Planning Officer: Ms Myer

Planning Application Ref: BN/17/21/PL

Location: The Cottage, Highground Lane, Barnham, PO22 0BT

Description of works: 1no dwelling. This application is a Departure from the Development Plan & is in CIL Zone 3 and is CIL Liable as new dwelling

PROJECT TITLE: THE COTTAGE HIGHGROUND LANE BARNHAM
DRAWING TITLE: PROPOSED DWELLING ADJACENT TO EXISTING DWELLING Existing Landscaping & Tree Plan
Drawn by: MJW DWG No: HL.PL003 REV No: / Date: OCTOBER 2020 A1 - 1:50

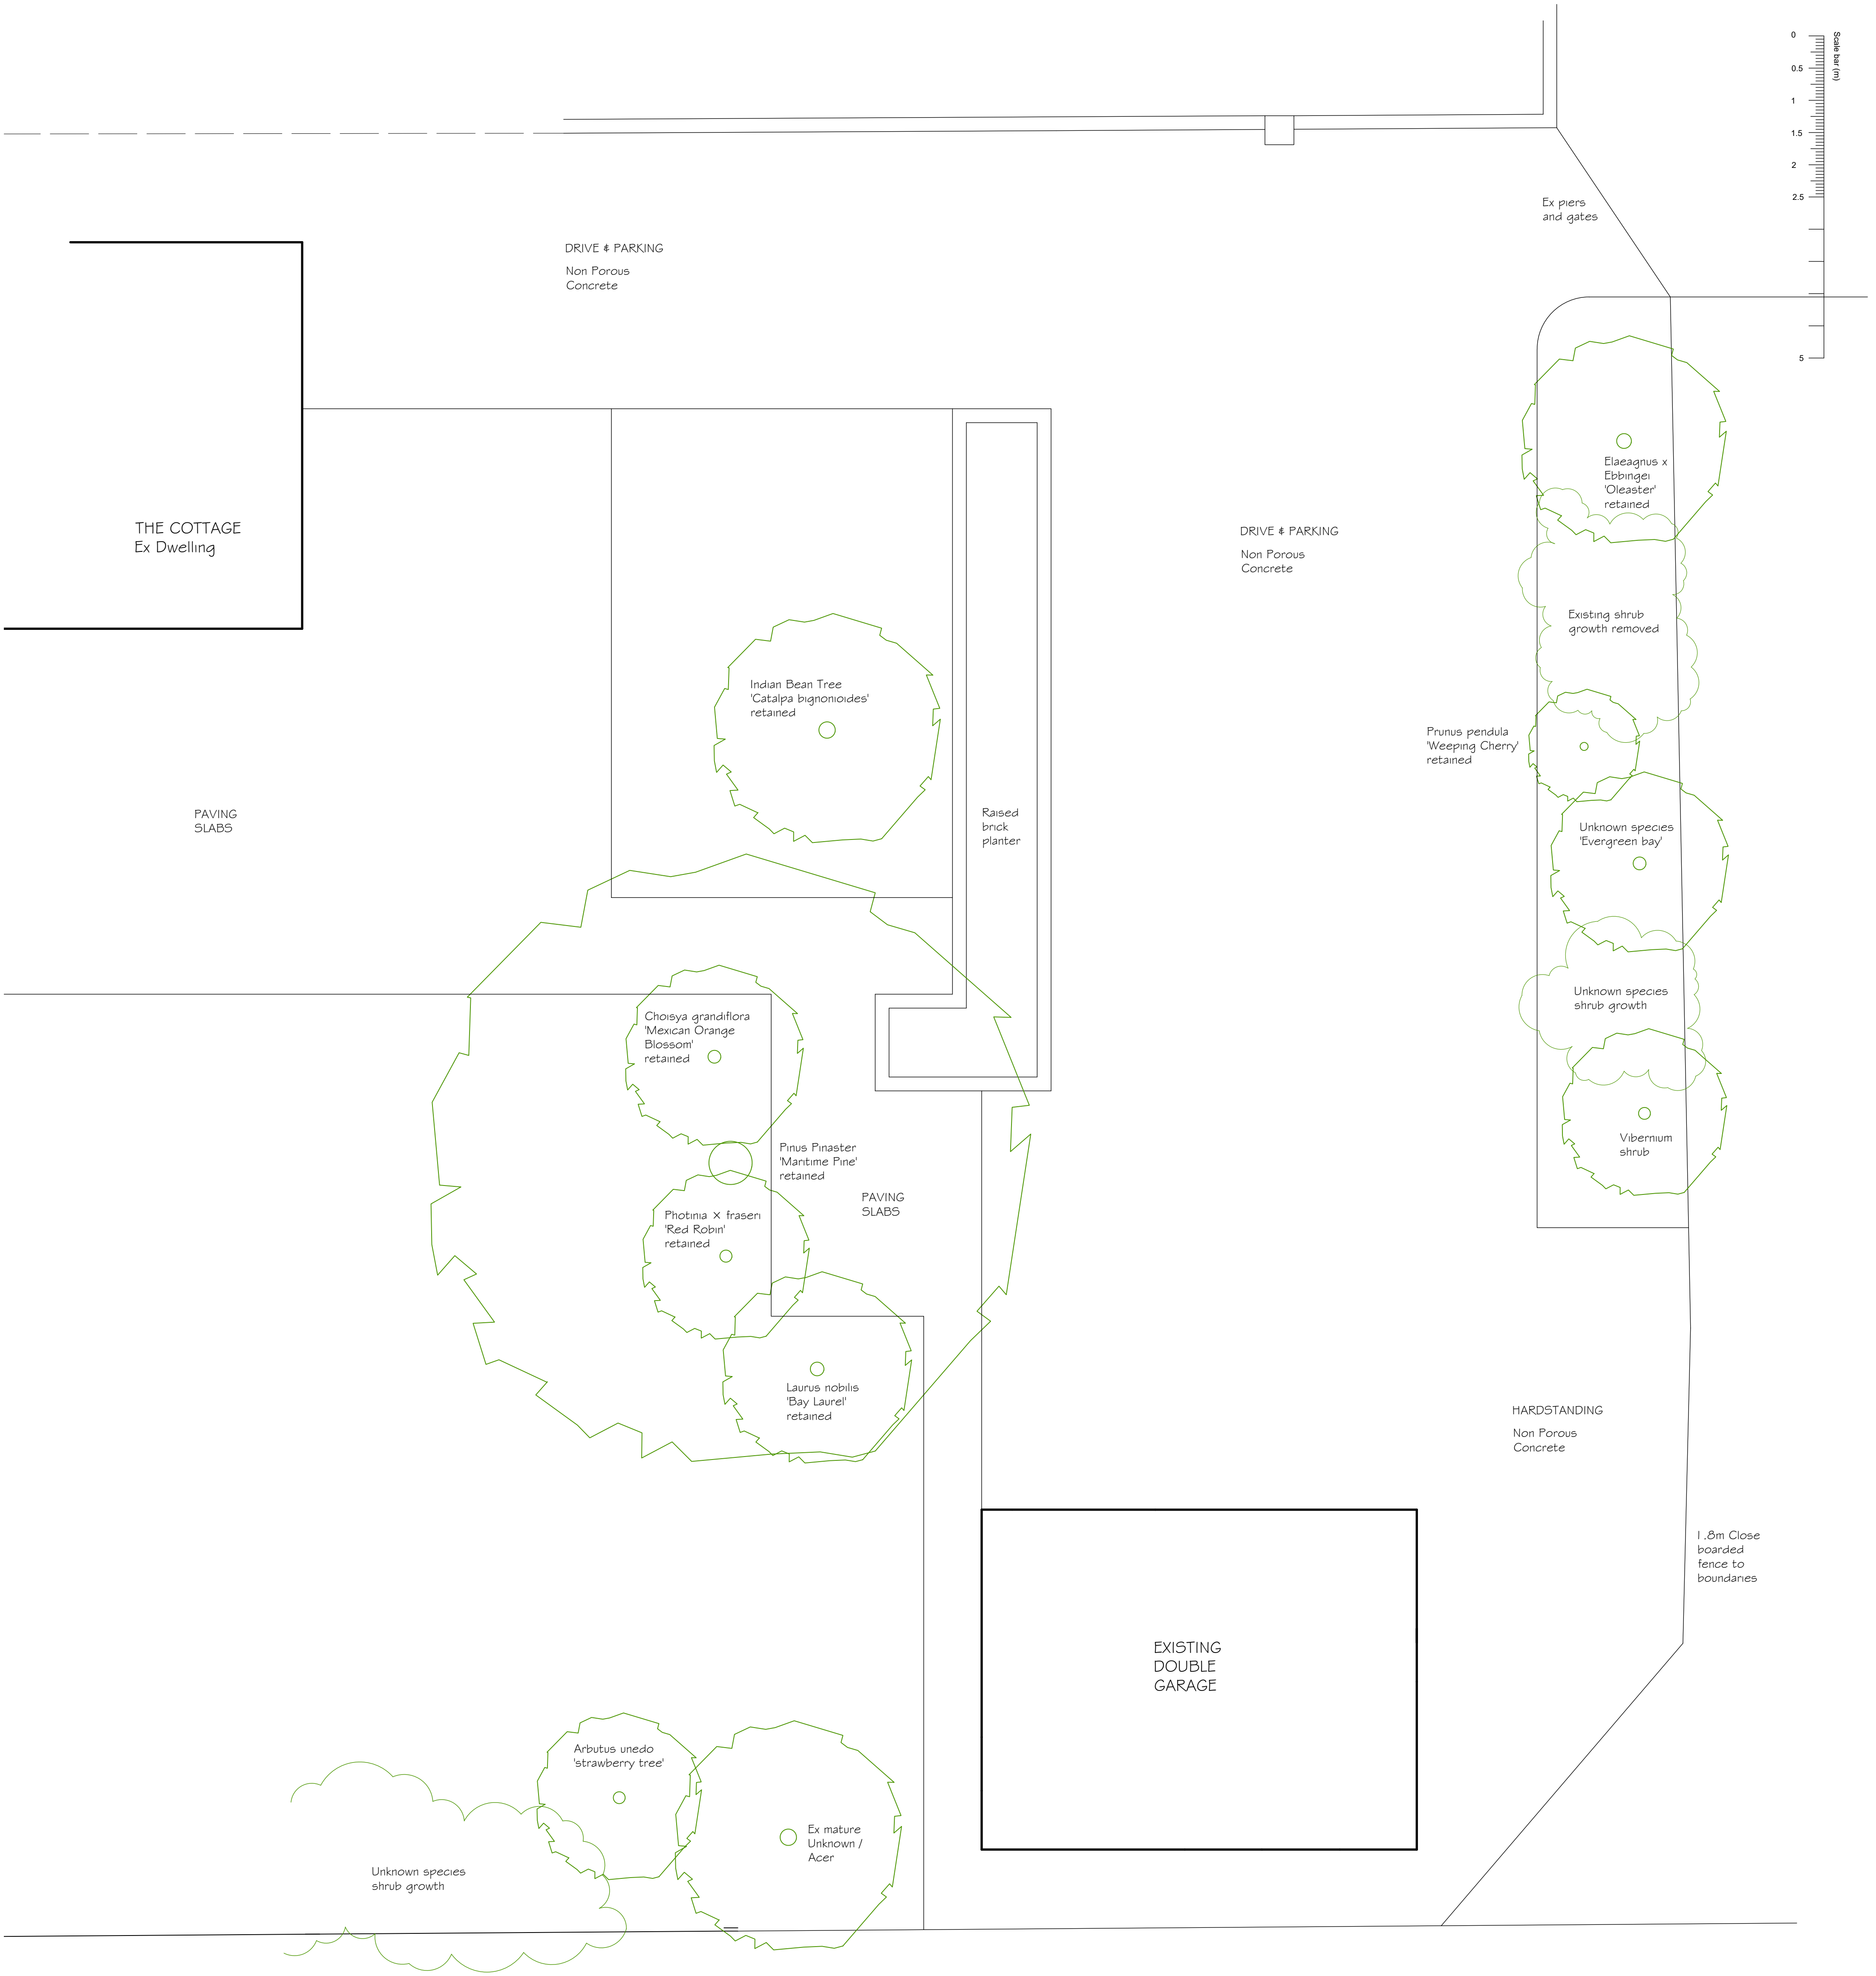
- The submitted drawing – Existing Landscaping & Tree Plan, HL.PL003 is indicative only and does not adequately assist our interpretation of the proposal. A BS5837 Tree Survey would provide us with a schedule of trees, root protection area schedule and be accompanied by a Tree Constraints Plan. This would be the minimum amount of information required for an outline application. For a full application such as this we will require that much and more (see recommendations).

1. The applicants will need to employ the services of an Arboricultural Consultant to carry out a tree survey exercise and then prepare an Arboricultural Impact Assessment (AIA) which must be inclusive of; a 'Tree Survey Schedule', a 'Root Protection Area (RPA) Schedule' and a 'Tree Constraints Plan' – with the trees accurately plotted on same.
2. In the event that a RPA of any tree which is proposed for retention overlaps the development then BS5837:2012 requires that the Detailed Planning Application is accompanied by an Arboricultural Method Statement (AMS) and also most importantly a Tree Protection Plan – to both describe and illustrate the mitigation measures which are to be employed to ensure that the trees survive without detriment to their vigour and vitality and are given adequate protection both above and below ground.
